24th August, 2015
Job no. MHM/PT/LH

NSW Department of Planning

Letter of Objection

Crown Sydney Hotel Resort (SSD 6957), Barangaroo

West elevation

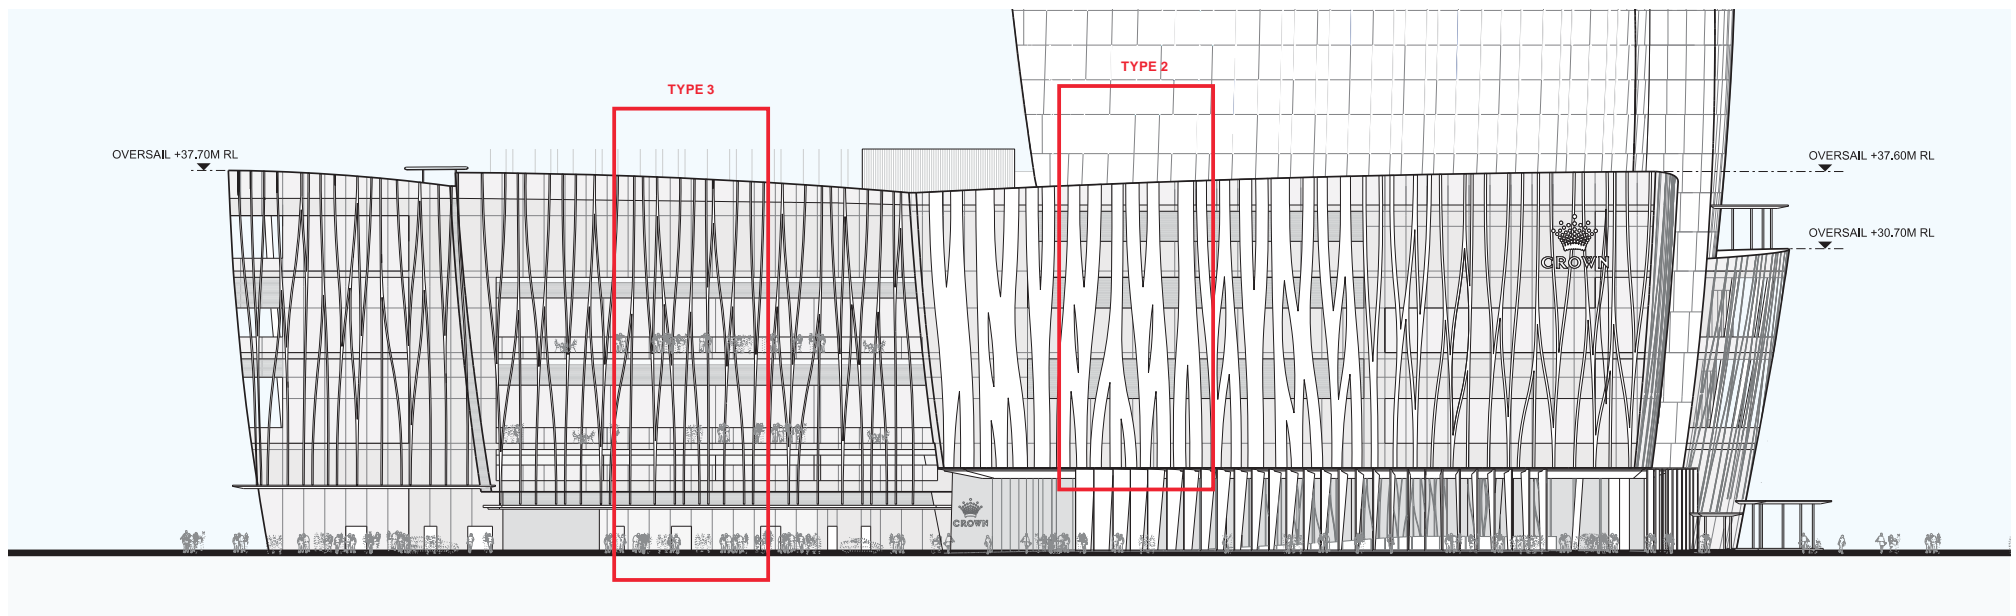
- 13 The design takes little account of environmental issues, such as exterior sun shading, reflectance, down draft and the like;
- 14 At 34m high and 130m long, the block form and podium is bulky and heavy-handed. Its street presence is dominated by the over-sized porte cochere, driveways and services, with little active frontage. Such an arrangement is unacceptable anywhere in the city, but particularly regressive on a publicly-owned, foreshore site;
